APPENDIX A – Response to Government Agencies and Organisations

State Significant Development SSDA 8669

St Aloysius' College

ROOF LEVEL PROPOSED SHADE AMENITY

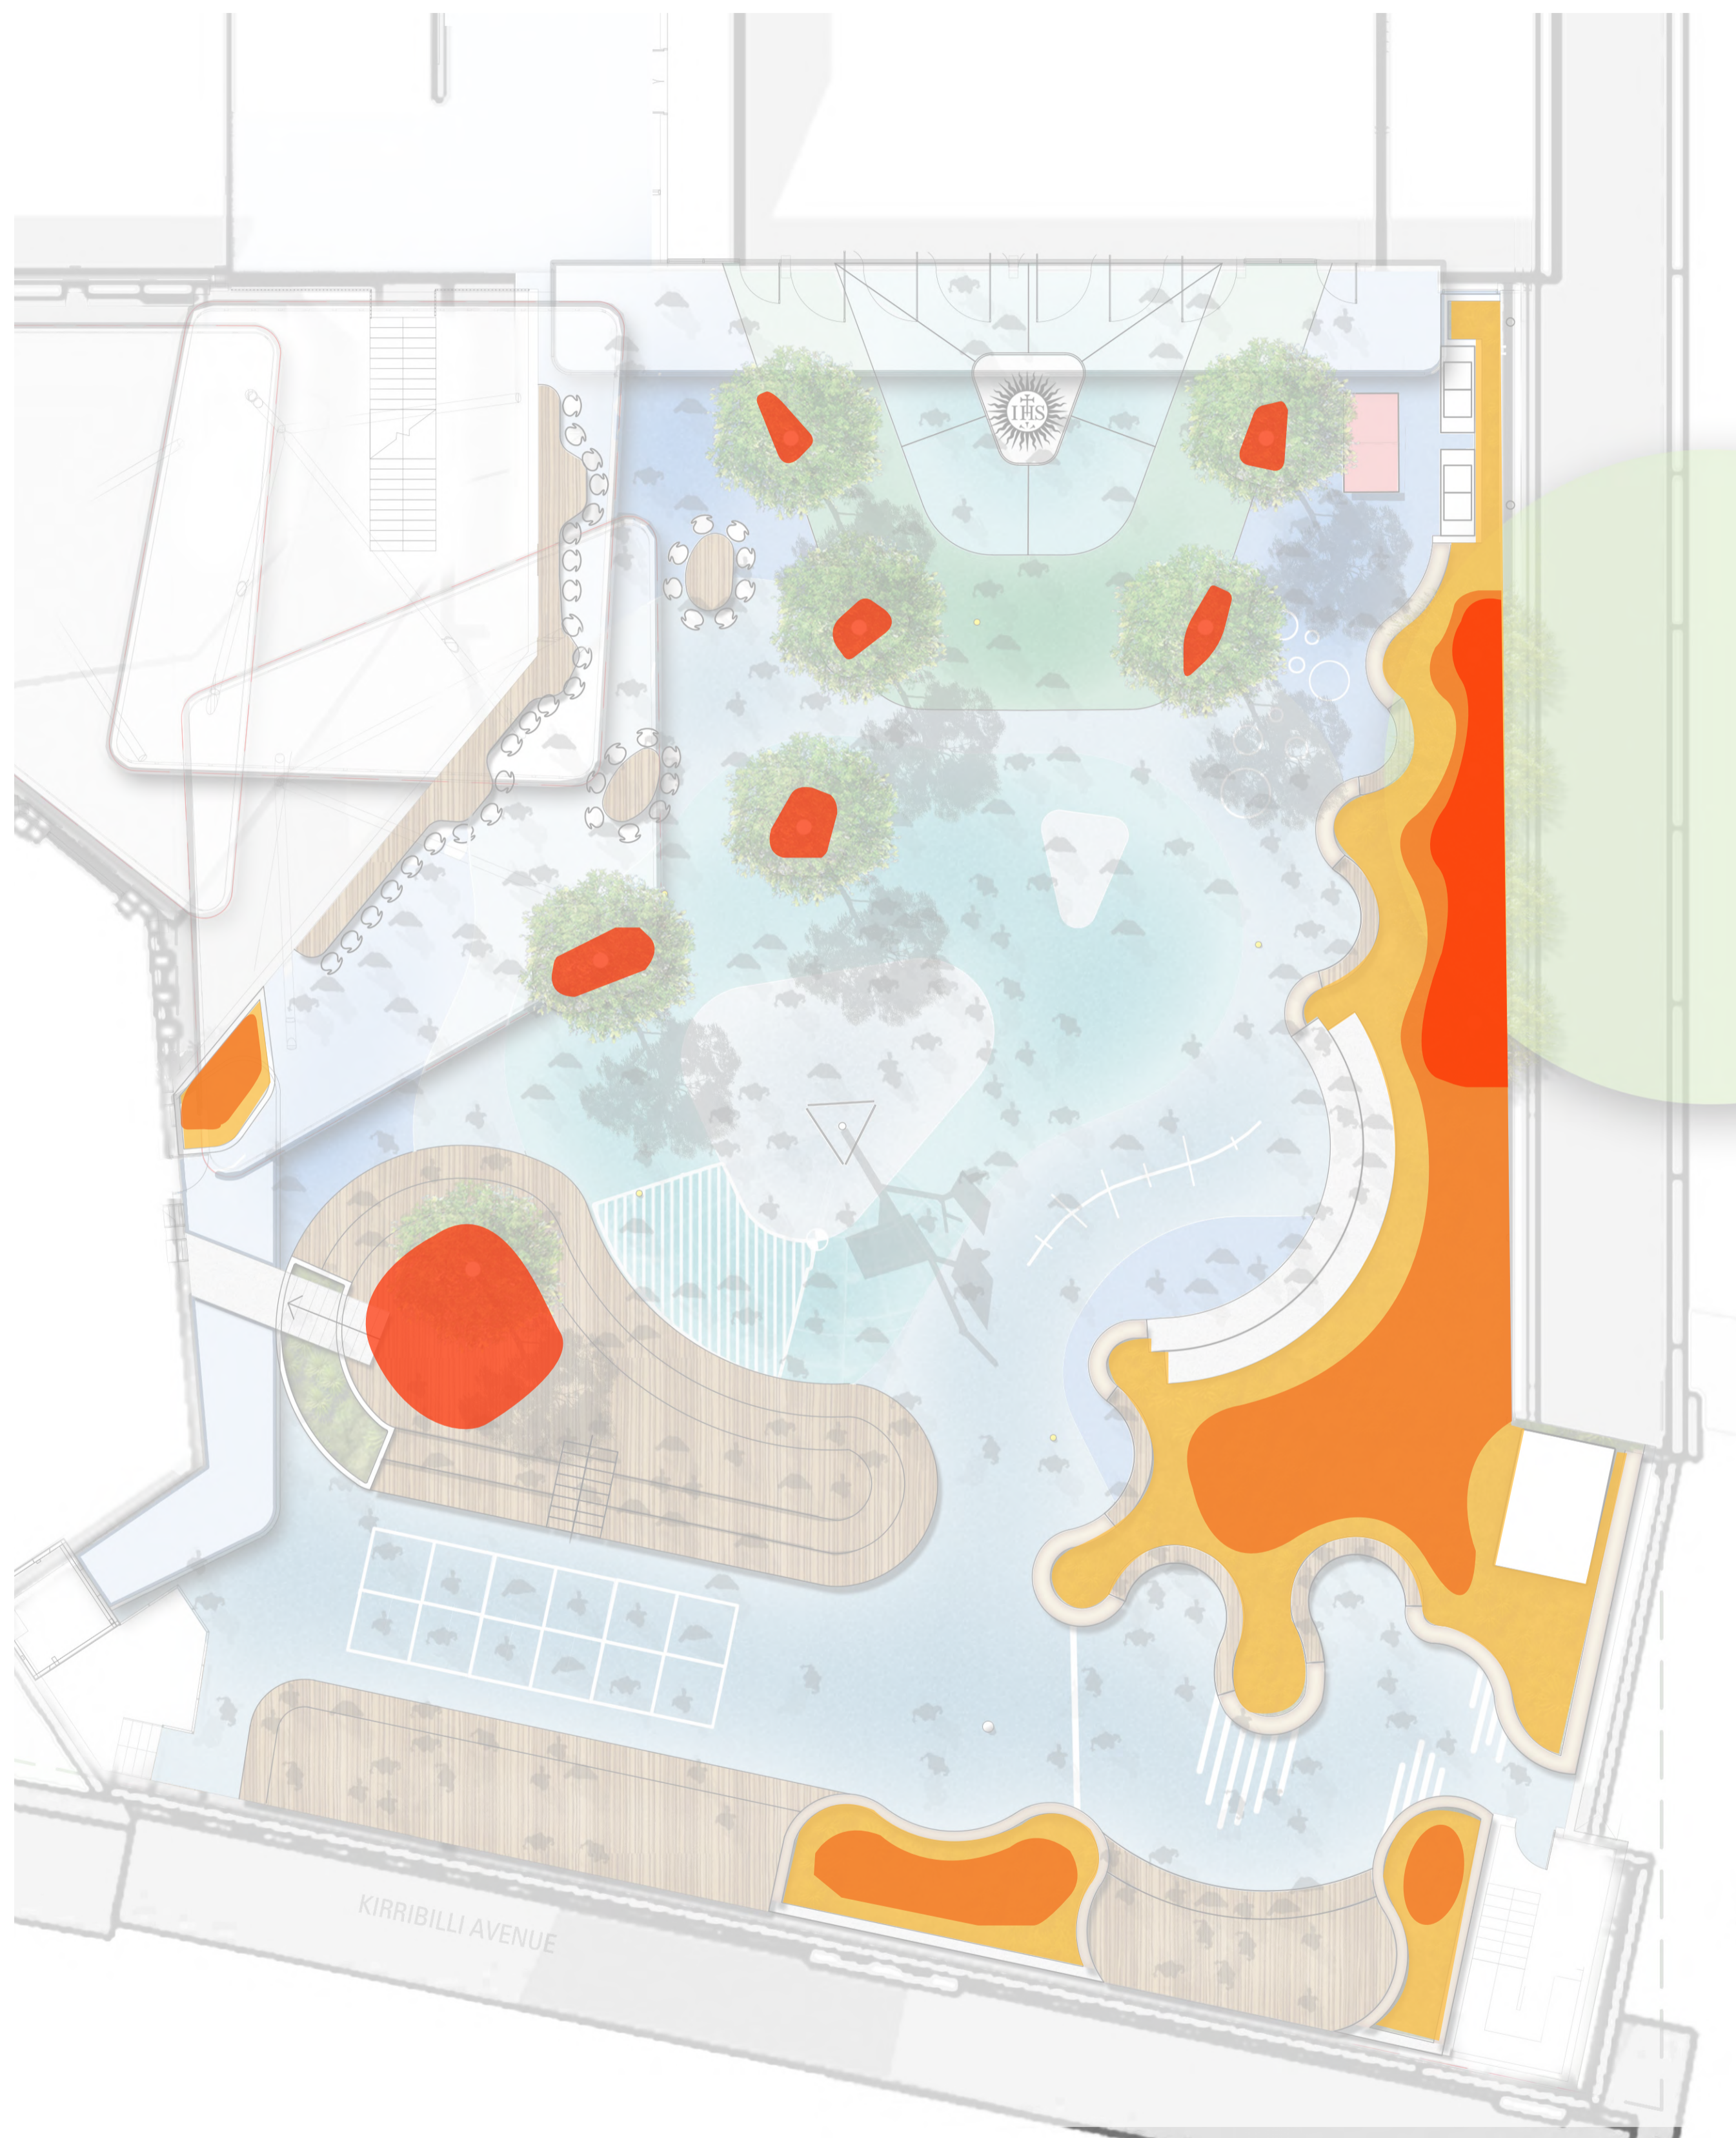
ISSUES RAISED BY AGENCIES AND ORGANISATIONS	PROPONENT'S RESPONSE
Provide justification for the location of the BBQ area, ping pong table and trees along the eastern edge of the proposed rooftop terrace, having regard to any potential impacts as a result of noise, overshadowing and view loss.	The location of the BBQ area, ping pong table and trees have been positioned to minimise undue impacts on the amenity of the neighbouring properties while providing a function and amenable recreational space. As stated in the Noise Impact Assessment prepared by SLR, the relocation of the recreational area from the ground floor courtyard to the rooftop terrace has in fact improved the overall noise impact on the surrounding developments. In addition, as indicated in the VIA, the proposed development will not result in undue impacts on view loss. The parapet height of the redeveloped north-east wing has been dropped by 270mm to be in line with the existing parapet height. The rooftop terrace and proposed structures will sit below the parapet of the north-east wing, and will not be visible from properties to the north.
